16 October 2008

**Submission
Proposed Queensland-Hunter Gas Pipeline
Major Project Application: 06-0286**

SURVEY EFFORT MAP 2.18 - GUNNEDAH

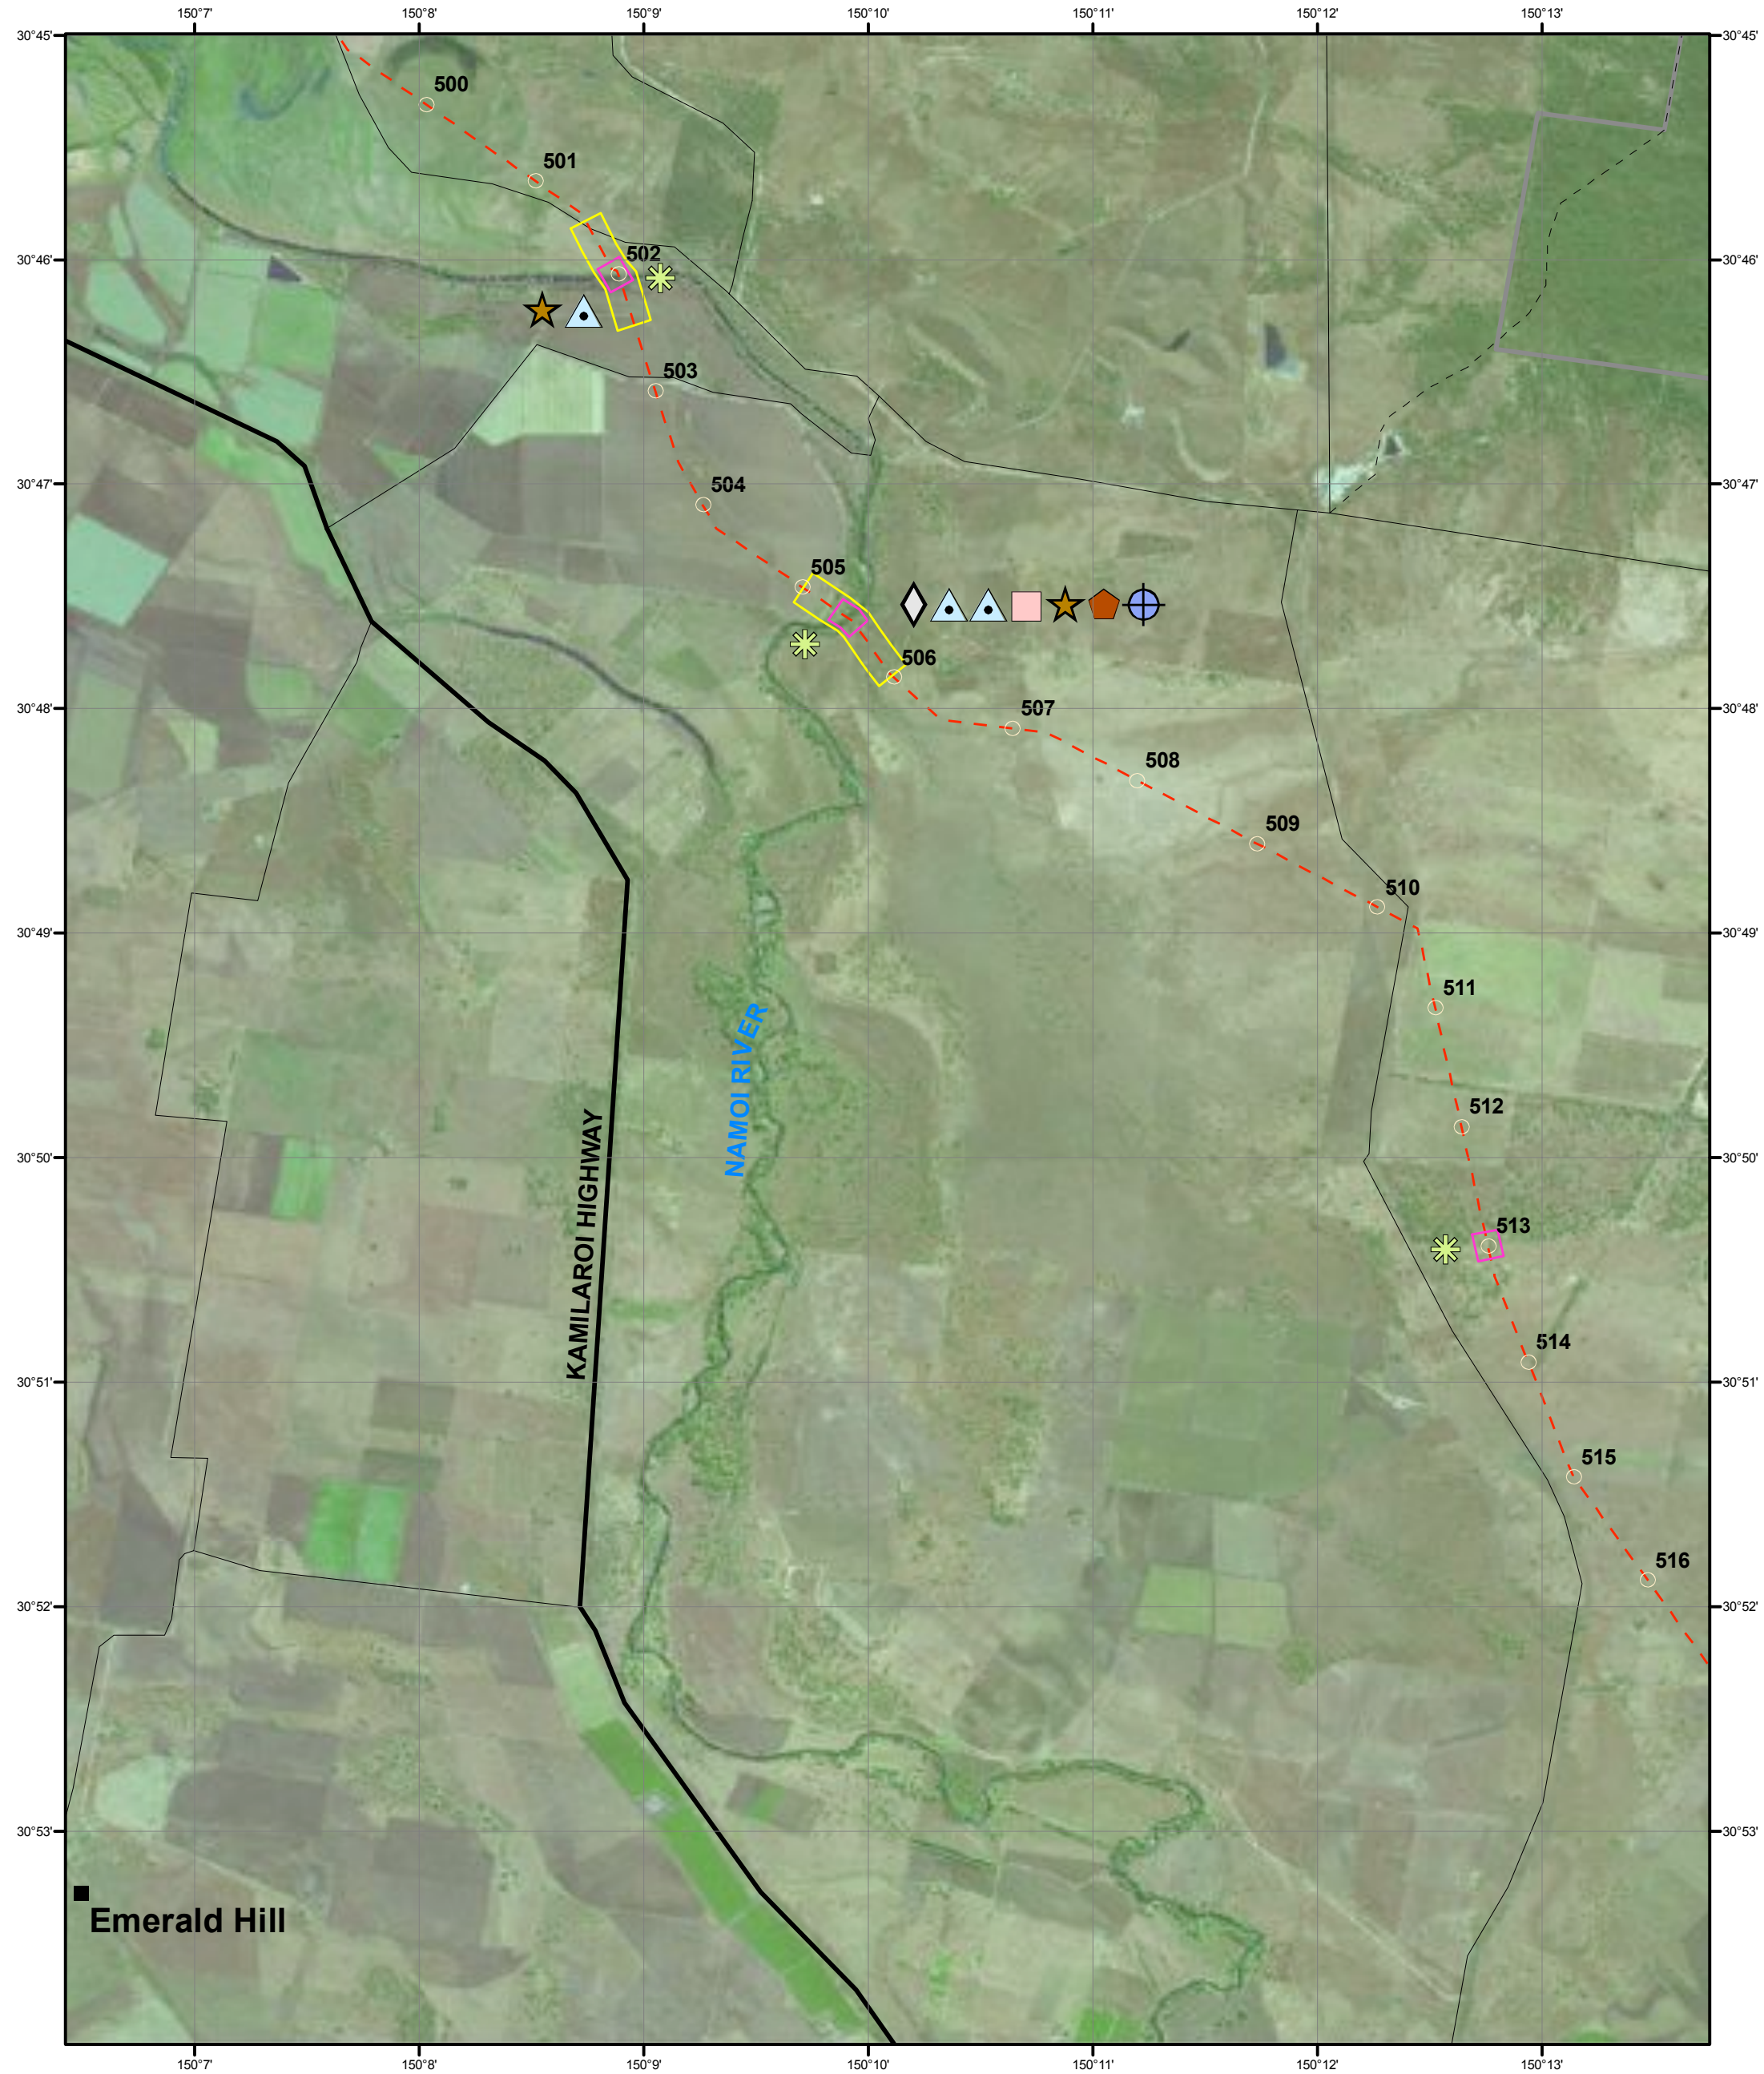
The proposed pipeline will pass through the Blue Vale Road and Orange Grove Road areas.

Council has considerable water supply infrastructure within these areas that may conflict with the gas pipeline location. It is unclear from the contents of the Environmental Assessment as to the precise location of the pipeline. The proponents must consult with Council relative to precise location of water supply infrastructure prior to installation of the gas pipeline.

Evaluation of the pipeline suggests that the pipeline will intersect with Council's Effluent Reuse Pipe that transfers treated effluent from the Gunnedah Sewerage Treatment Plant to the irrigation property 'North Gunnible' in the vicinity of Wean Road. Consultation with Council is required to ensure that the integrity of the effluent pipeline is not compromised.
